# 175 – 177 Cleveland Street and 1 - 5 & 6 - 8 Woodburn Street, Redfern

## Design Review Report

On behalf of  
EG Funds Management Pty Ltd  
September 2022

9AM JUNE 21 - SHADOWS
1:500

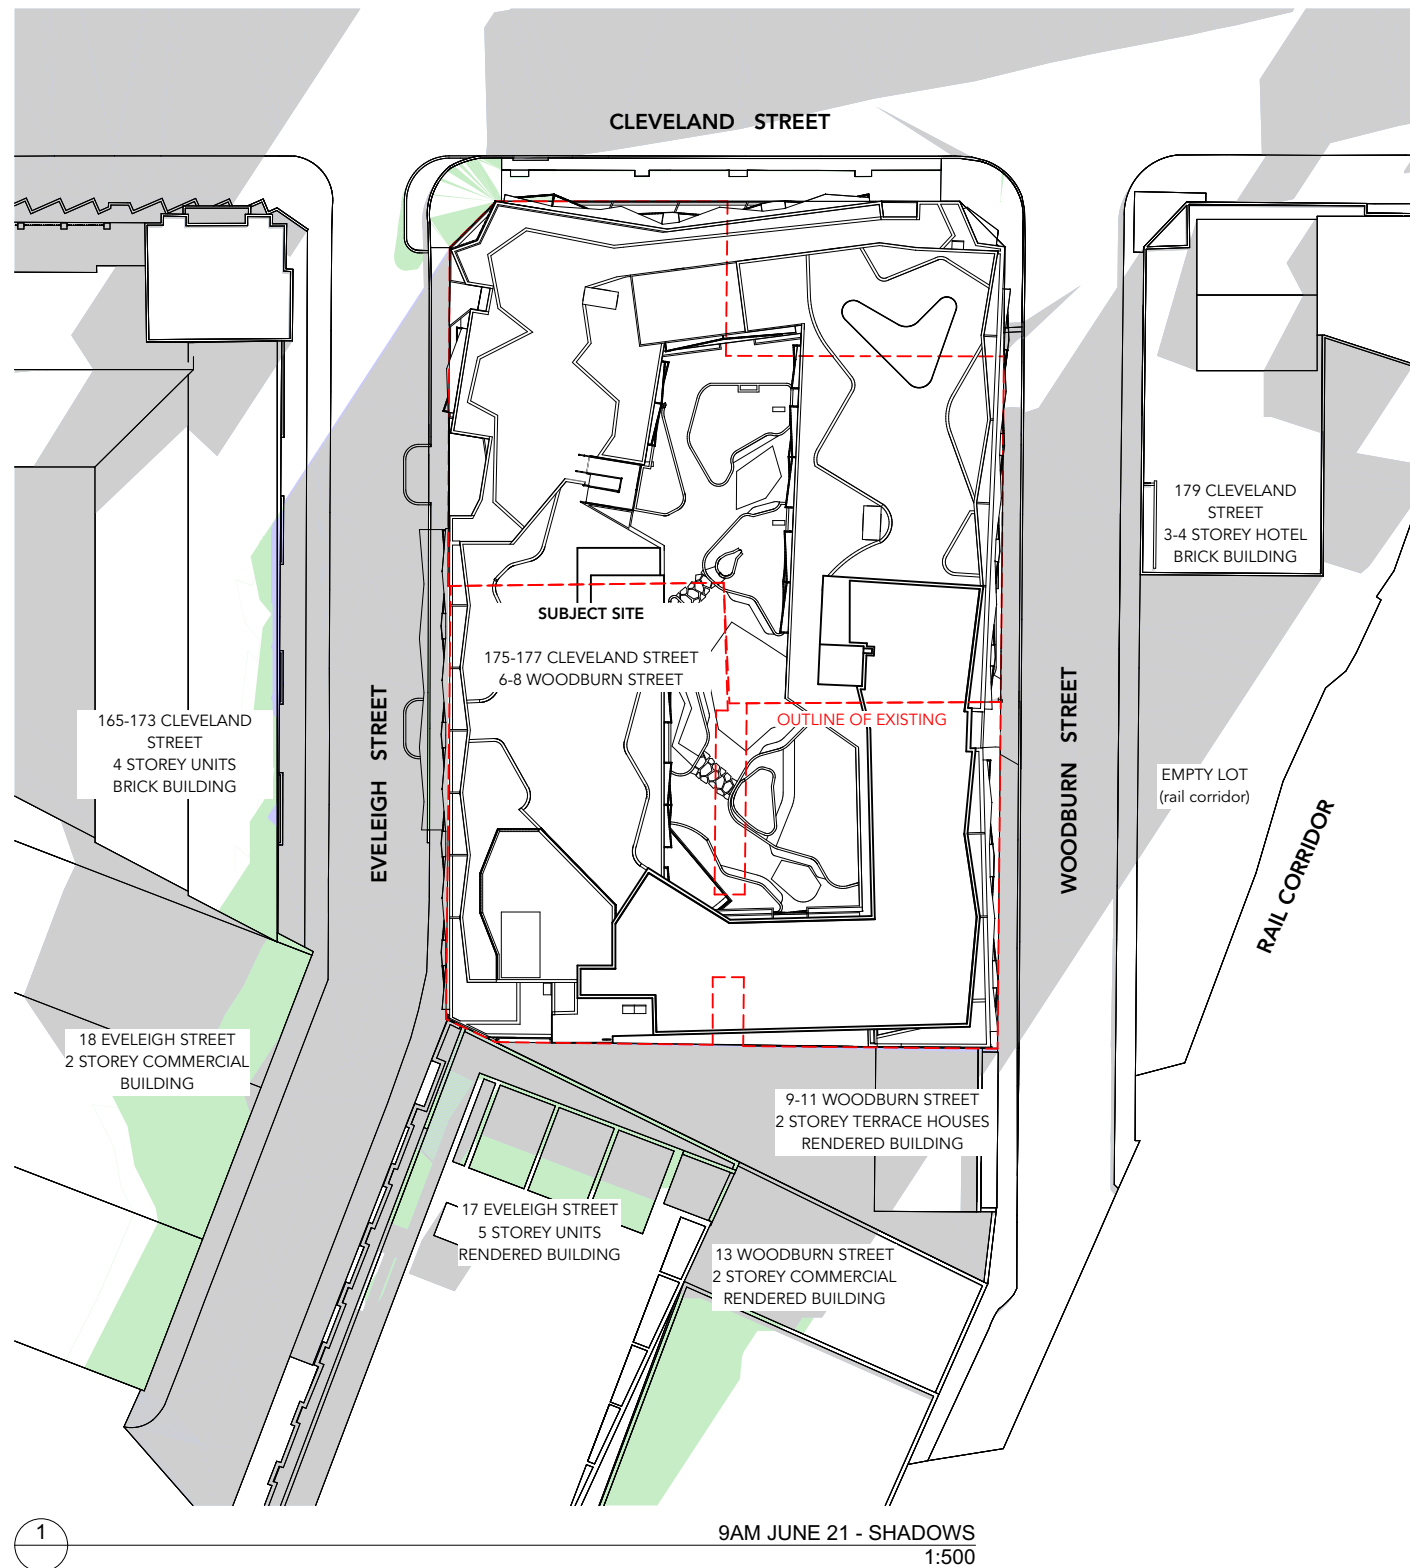
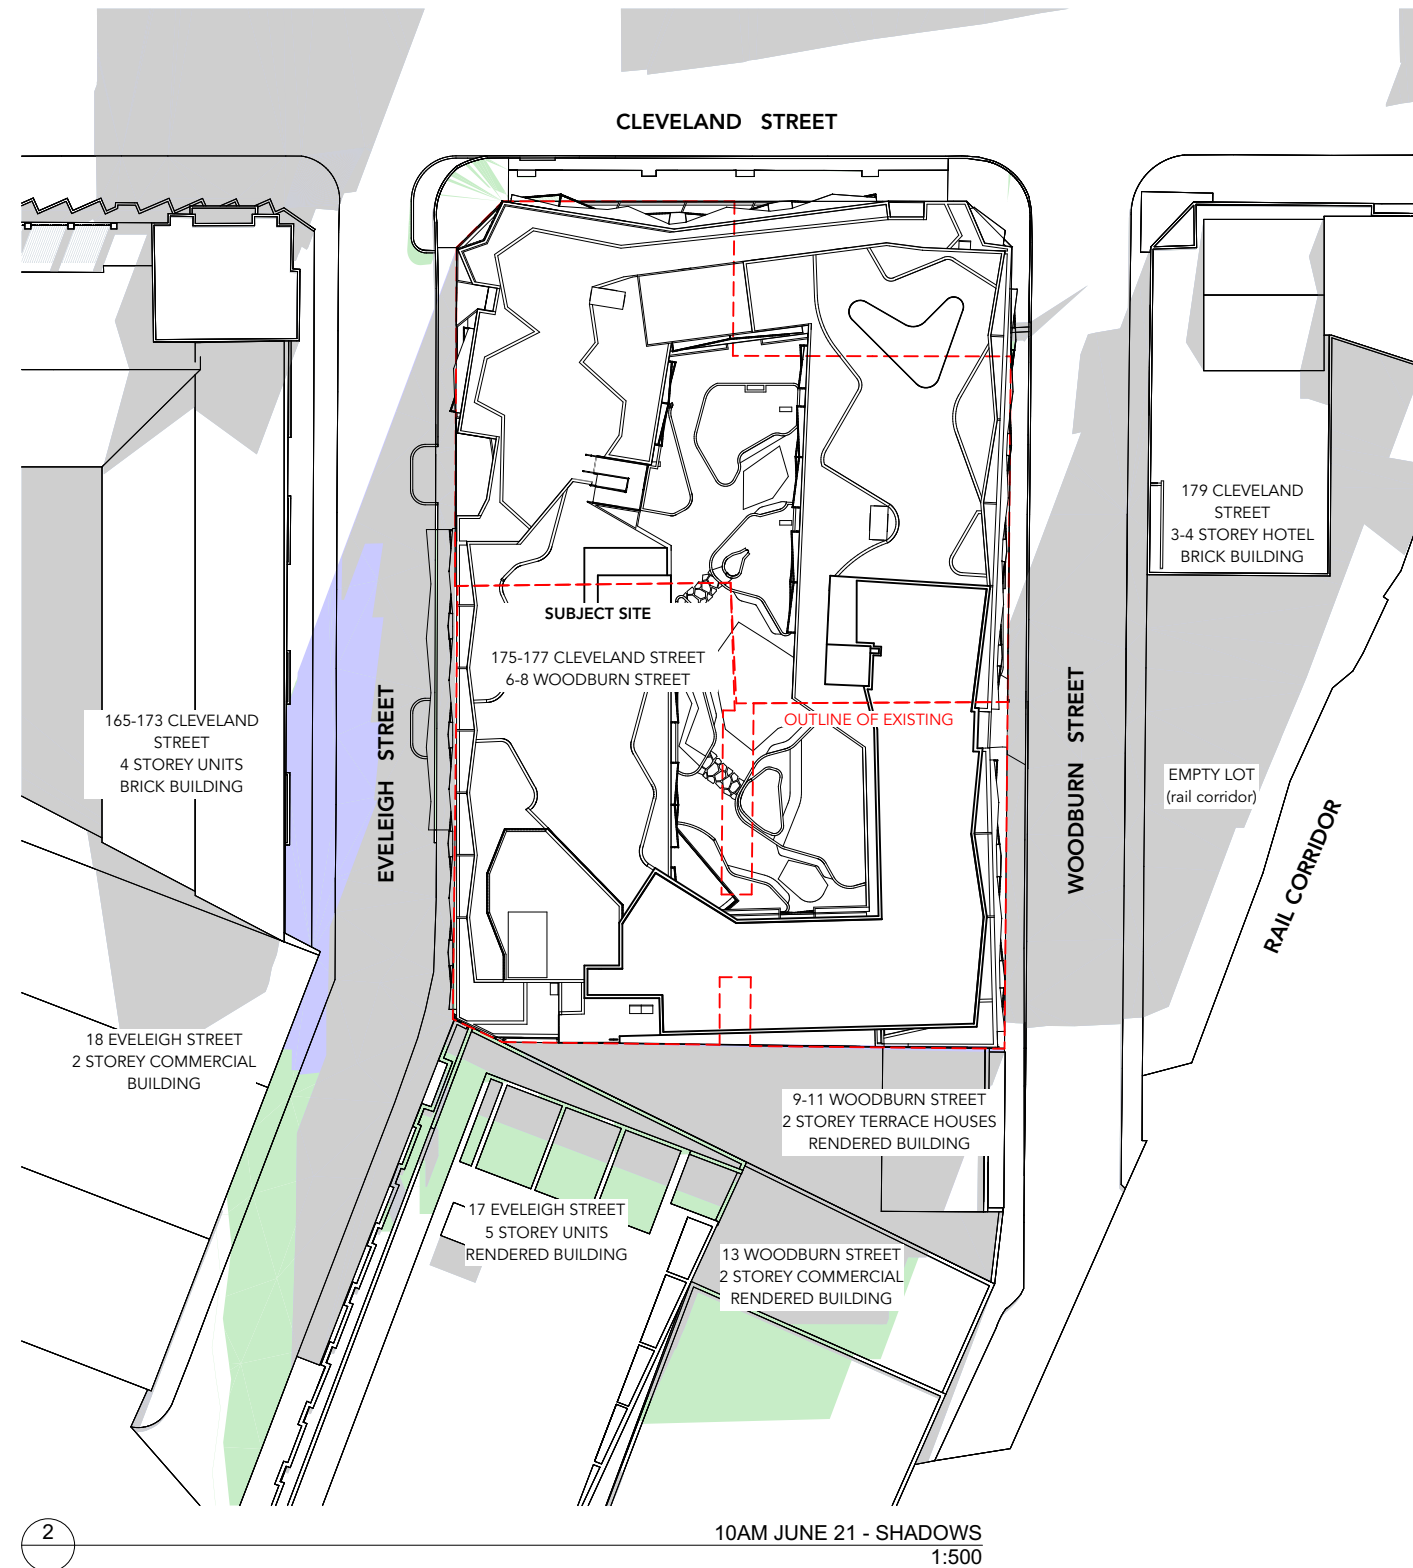
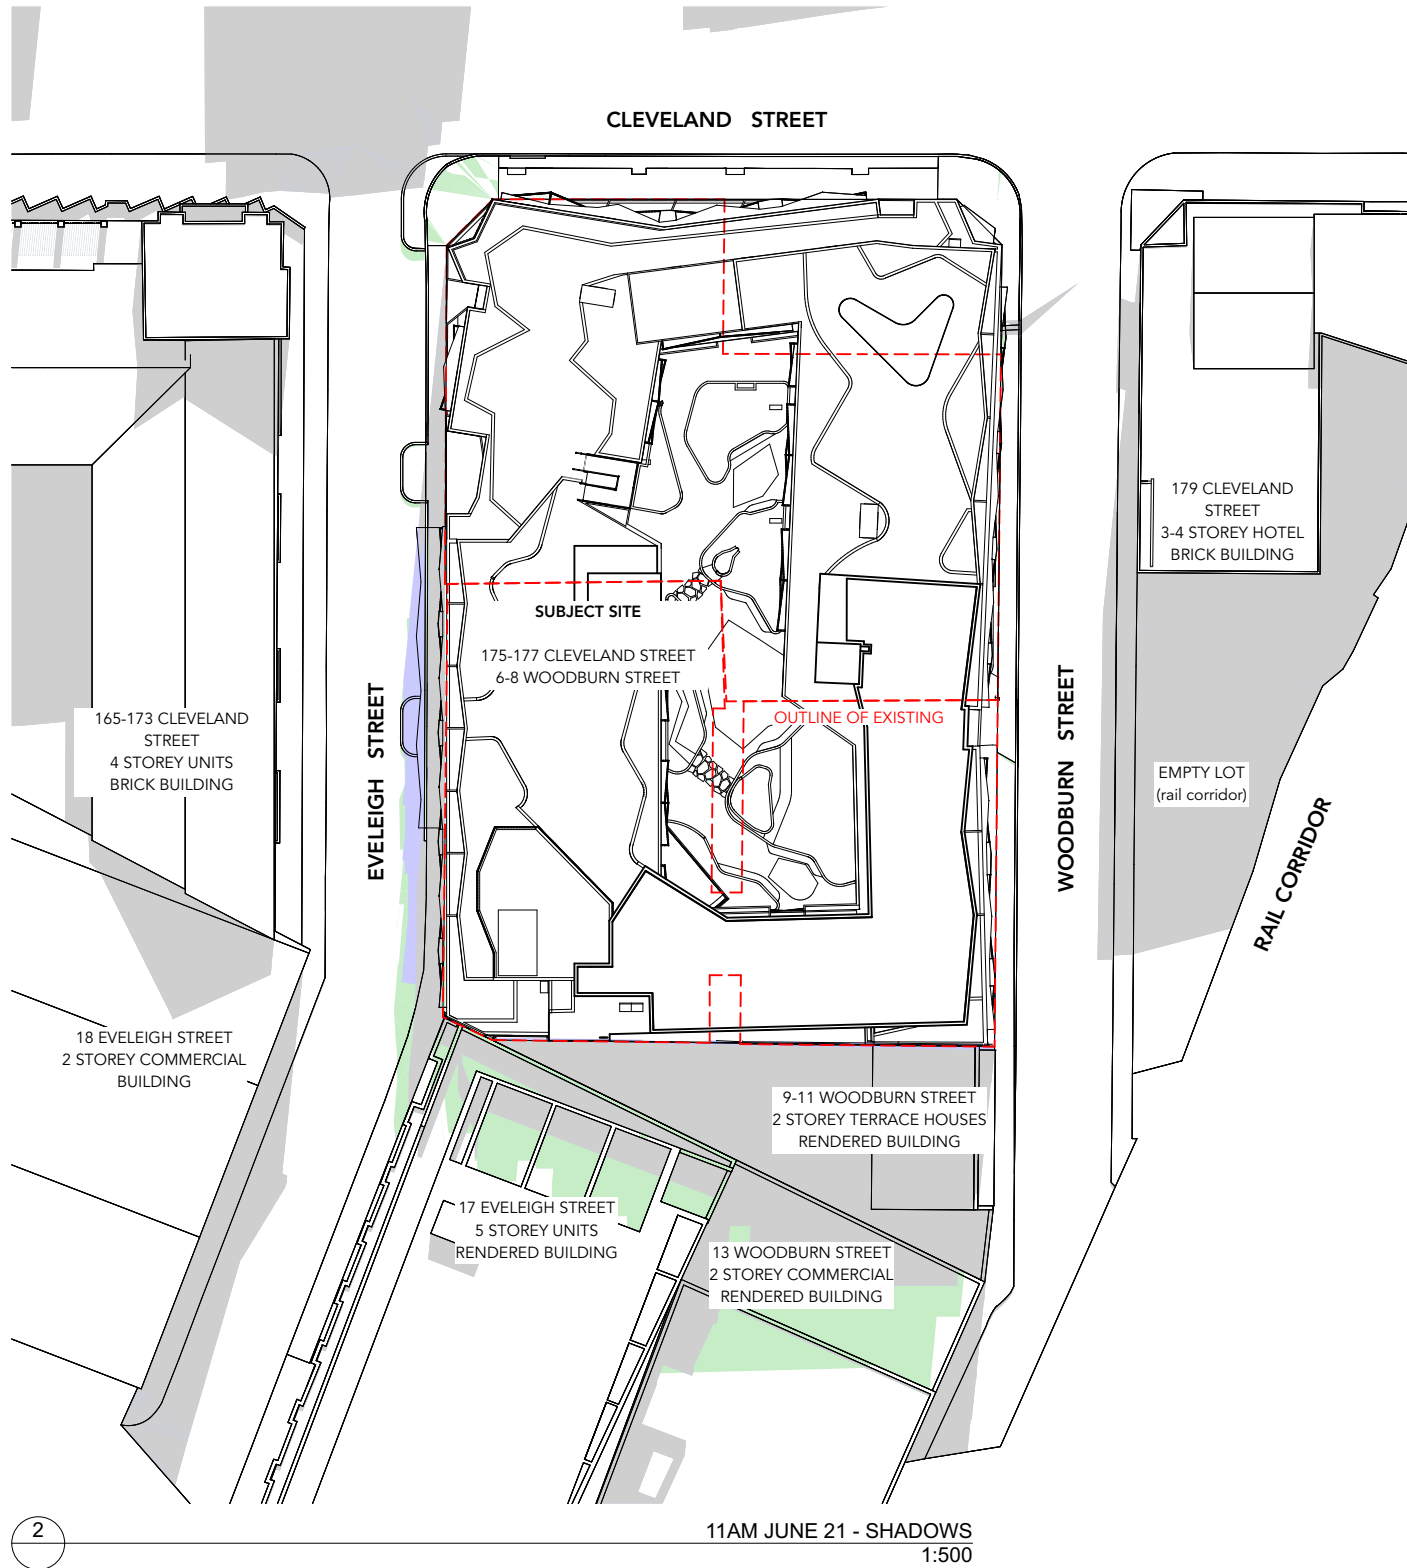
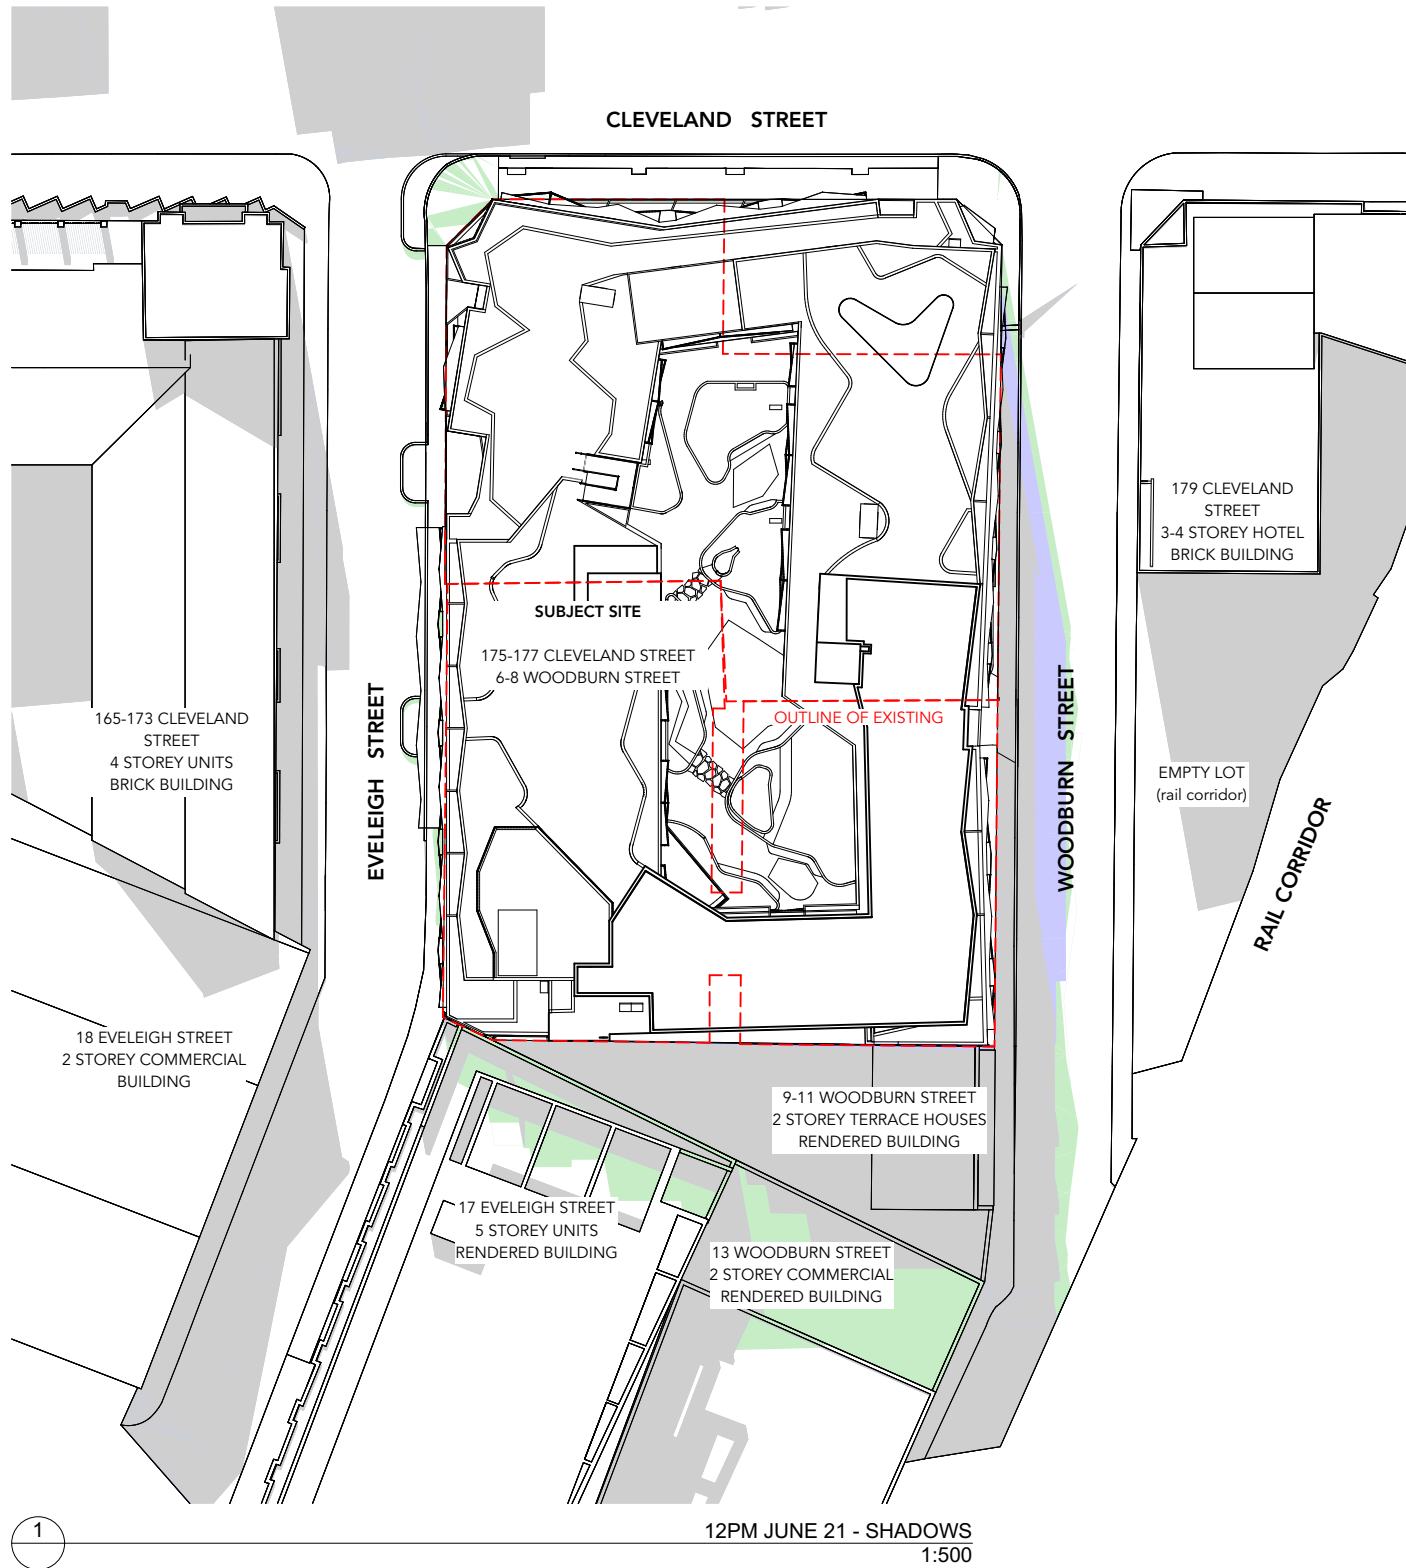
10. Prioritise quality open space that has access to sunlight throughout the year. Test massing options that increase sunlight to the courtyard, including removing the central bridges.

The **Housing SEPP** requires an amount of communal open space equivalent to 20% of the site area which equates to a **minimum of 403m<sup>2</sup> of communal open space required**. The Housing SEPP does not prescribe a minimum amount of sunlight access to communal open space.

The **Sydney Development Control Plan 2012** (SDCP 2012) requires a **minimum of 20m<sup>2</sup> of communal open space**. The SDCP 2012 requires that communal open space be generally north facing with a minimum 2hrs solar access to at least 50% of the area.

The proposed scheme provides a **total 1,458.8m<sup>2</sup> of communal open space** between ground, level 5 and level 6. **903m<sup>2</sup> of this area is provided on levels 5 and 6** and receives nearly full solar access throughout the day.

Given the site context and conditions, particularly from Cleveland Street, providing increased solar access to the courtyard is extremely challenging and would ultimately be at the detriment of the internal amenity of the building. Accordingly, to achieve the minimum communal open space and solar access requirements under the guiding policies identified above, generous opens space areas have been provided on the upper levels to deliver on the necessary amenity requirements for residents.

Further to the above, while the ground floor courtyard receives minimal solar access during winter months, it is important to note that during the majority of the year, this area will benefit from increased solar access.
